City of Portland, Maine - Building or Use Permit Application
 389 Congress Street, 04101 Tel: (207) 874-8703, Fax: (207) 874-8716

Permit No: 04-1567	Issue Date: NOV 17 2004	CBL: 390 A010001
-----------------------	----------------------------	---------------------

TO: Inspections Department
FROM: Jay Reynolds, Development Review Coordinator
DATE: April 7, 2005
RE: C. of O. for #118 Hope Avenue, PRP III lot 4
(CBL390A010) (ID#2004-0216)

2003 INTERNATIONAL RESIDENTIAL CODE®
FOR ONE- AND TWO-FAMILY DWELLINGS
2003 PLAN REVIEW RECORD

Drawing Name: Lot 4 Grading & Drainage Plan
Project: PRESUMPCOT RIVER PLACE

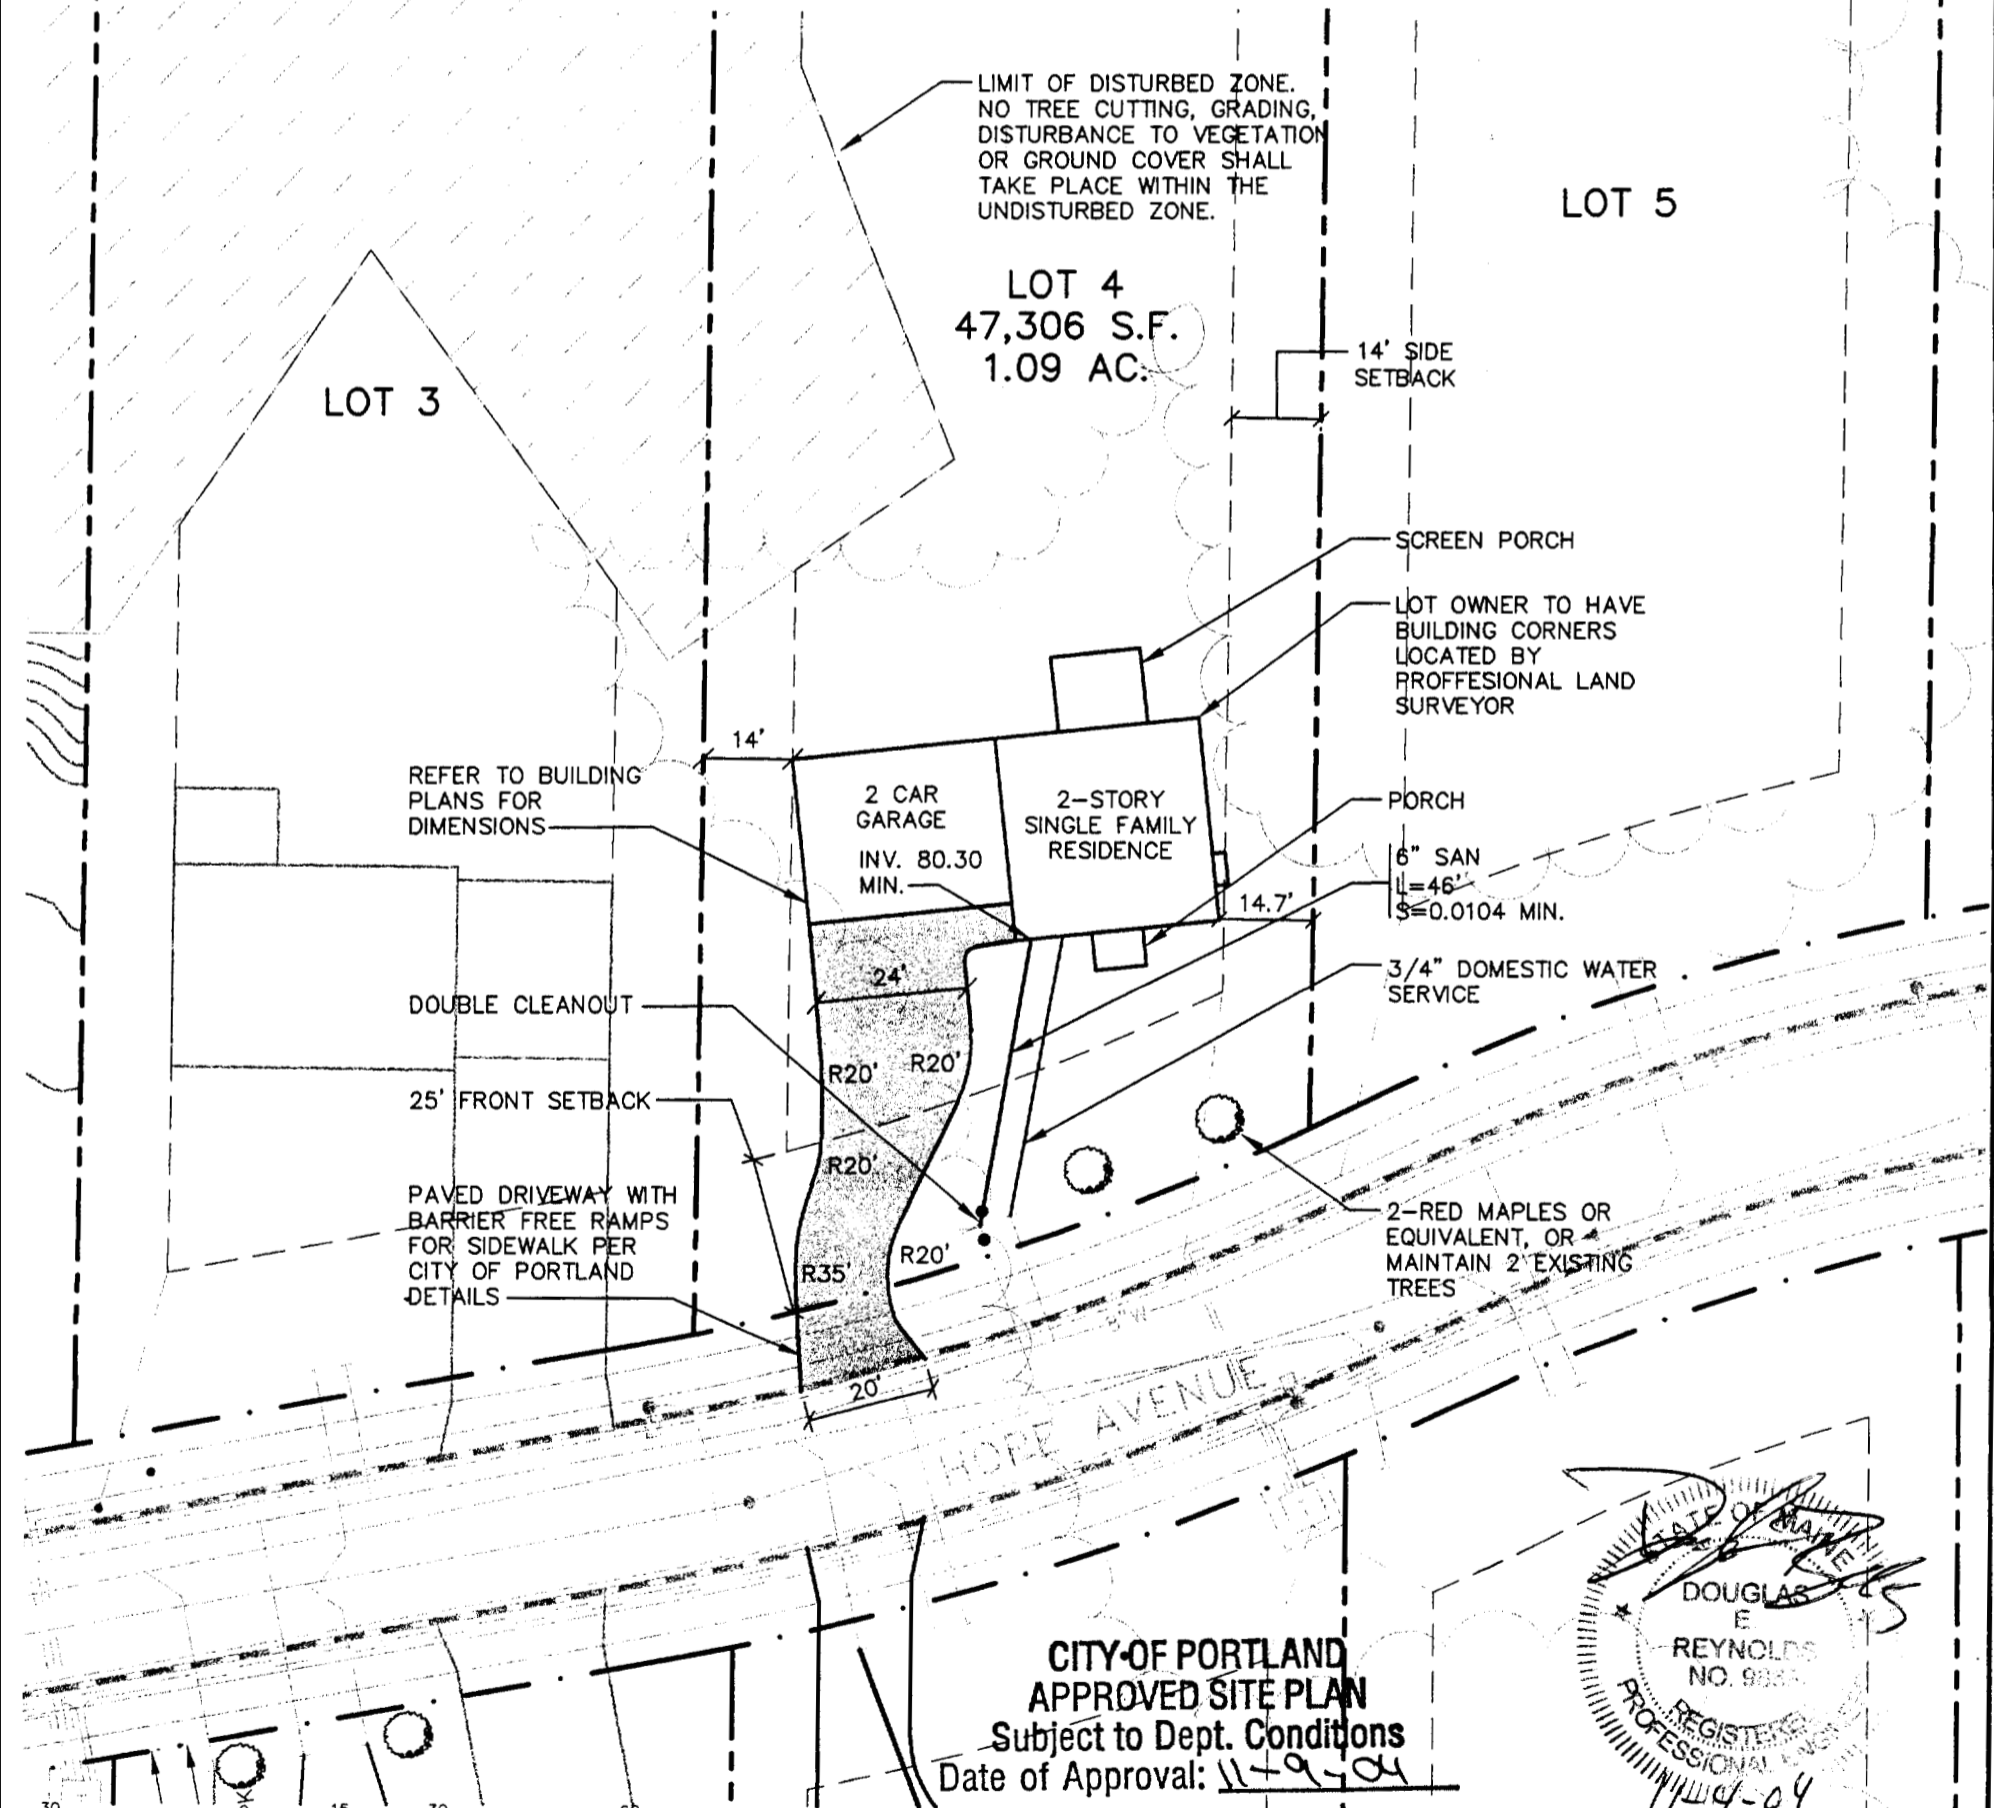
Site work incomplete:

1. Final Paving
2. Loam and Seed
3. Landscaping
4. Engineering Certification of completion

I anticipate this work can be completed by **June 15, 2005**.
At this time, I **recommend issuing a temporary Certificate of Occupancy**.
